Your Ref: OWPC3823
Our Ref: FP/132/14/HH 28-07-2014
Please ask for:
Mrs J Chapman

Erection of a pagoda style carport
10 Grafton Avenue Bognor Regis

Thank you for your internet representation made on 10th September 2014 which has been recorded as '**an objection**' with the comments as follows:

FLOOR PLAN DRAWN AT 1:50 SCALE

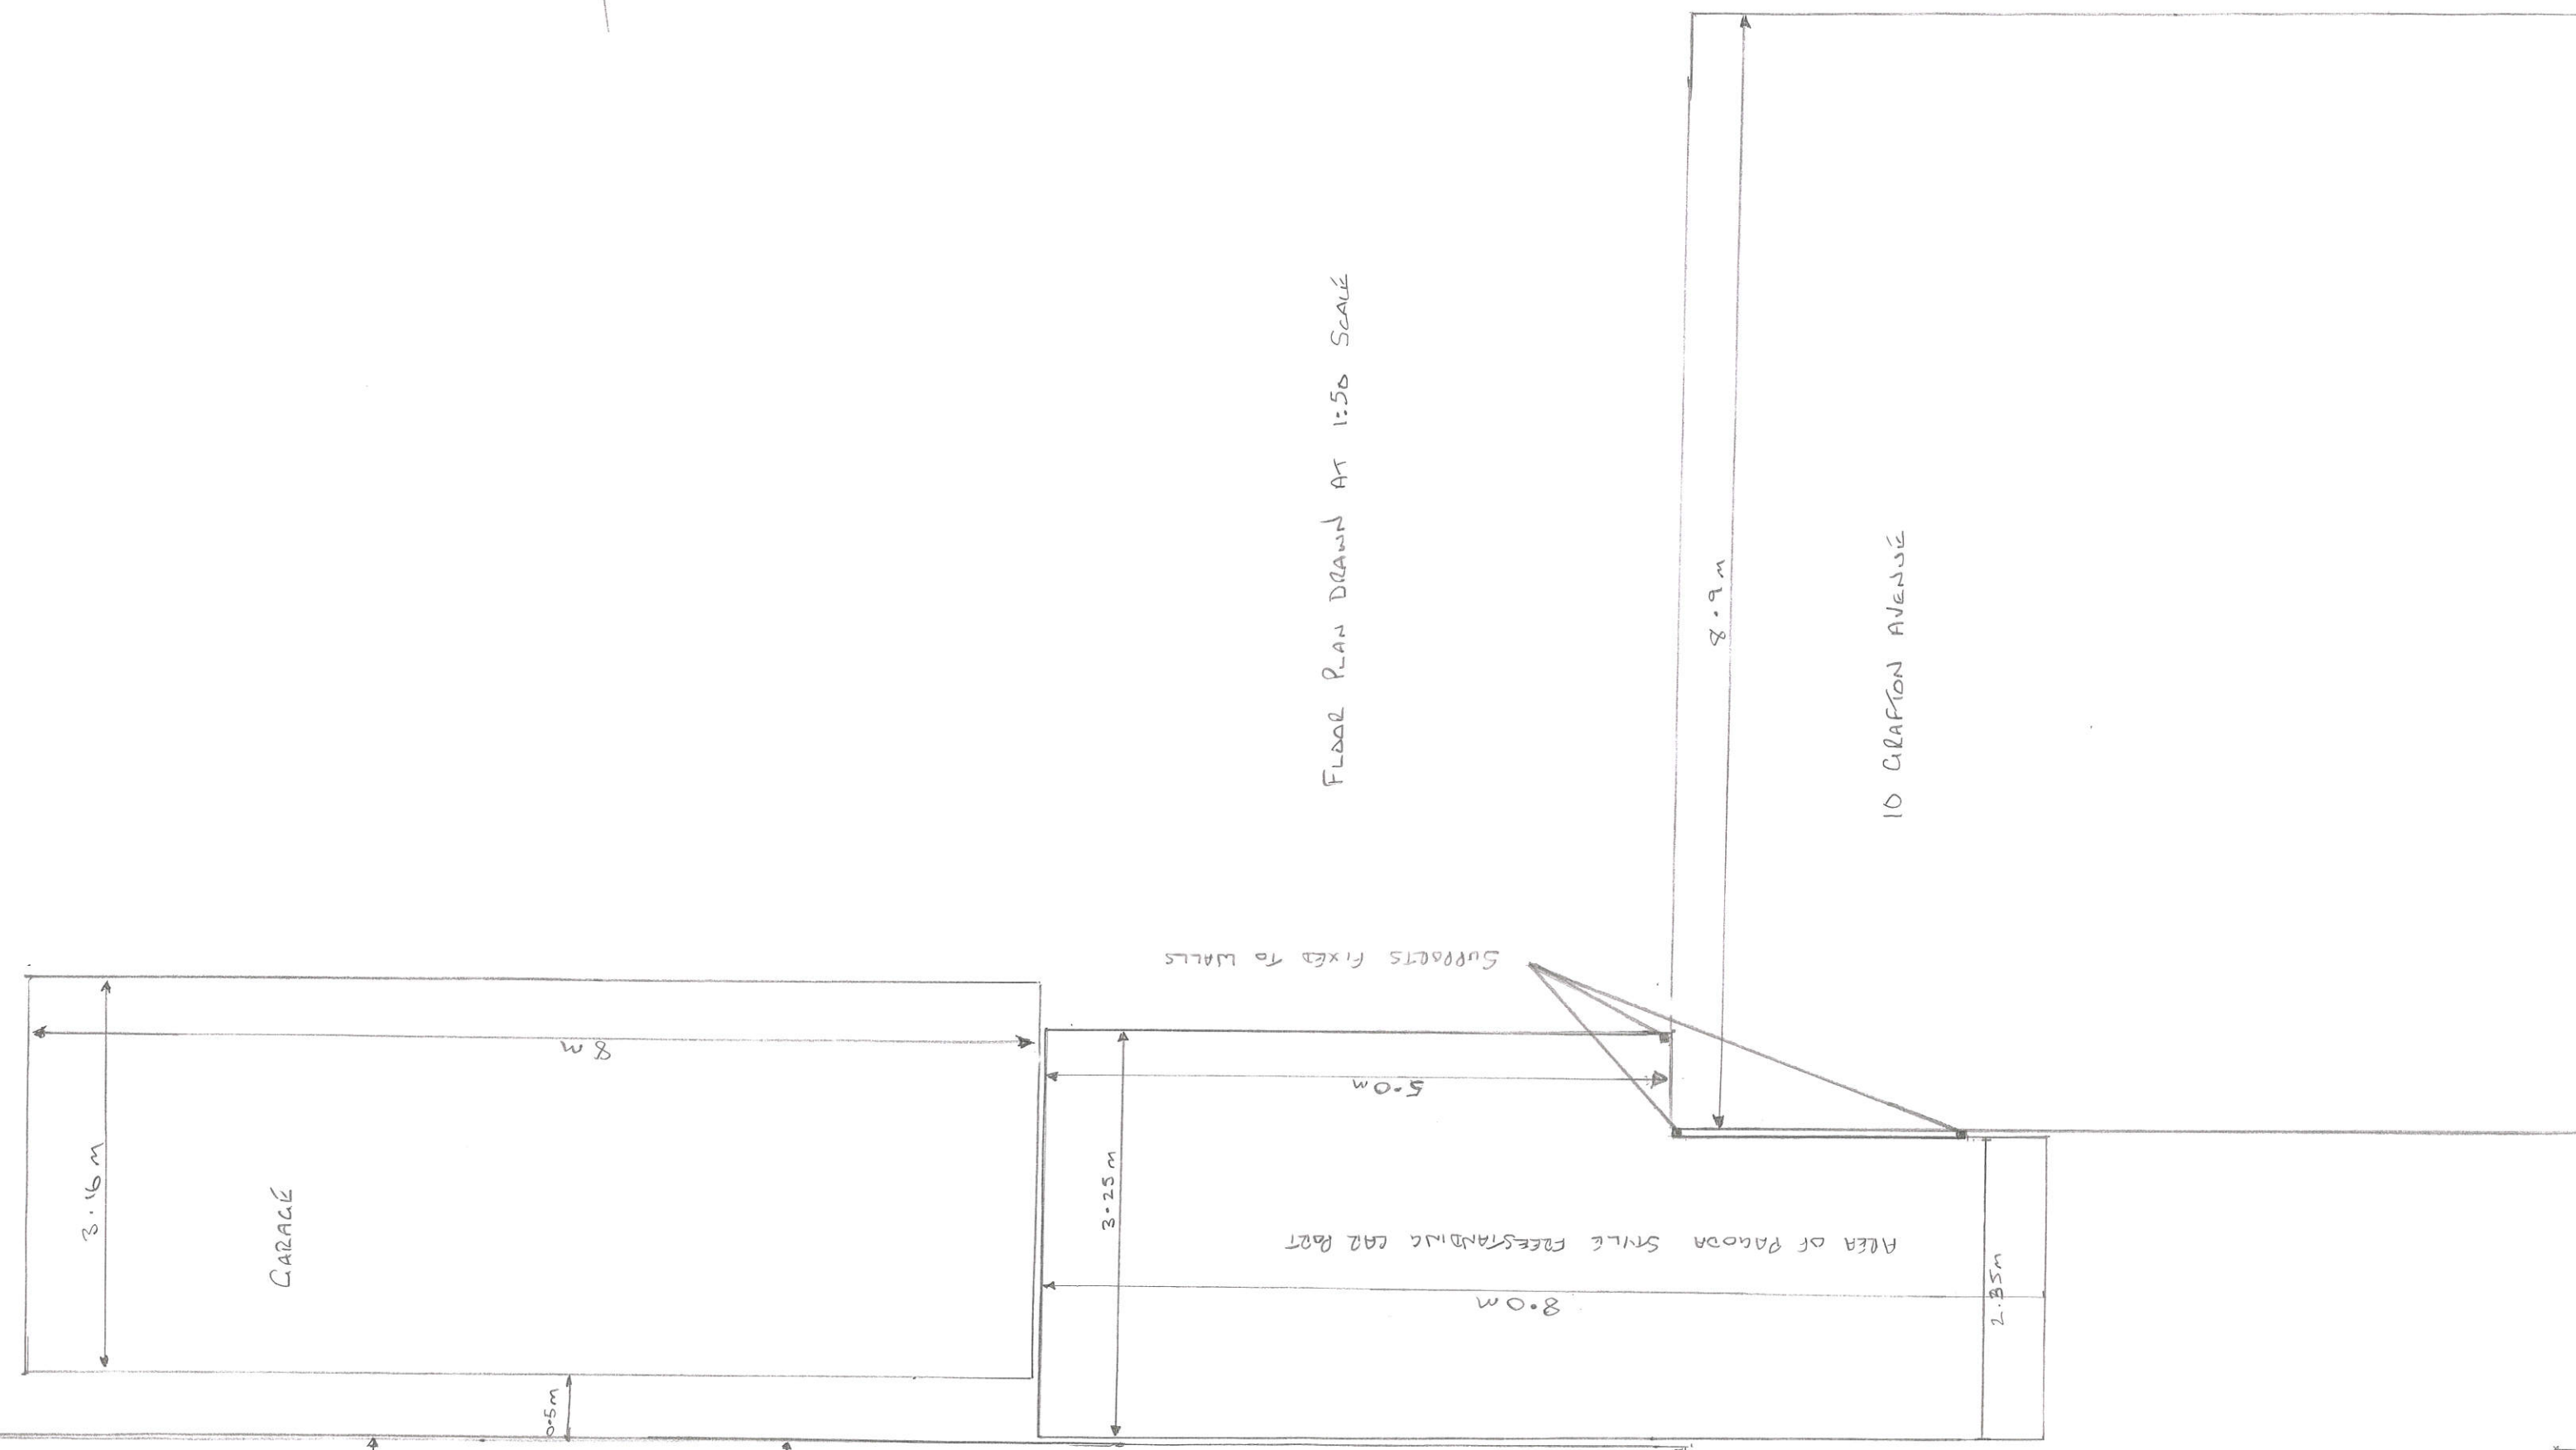
*We are not happy because the car port is too close to our boundary line and close adjacent to our property wall, the distance from car port to our property is approx 1foot 6inches. (How can we maintain our wall against car port obstruction)
Also aware of rain water flow against our back garden and our property wall.
We dont want to have anymore problems with car port against our property side.*
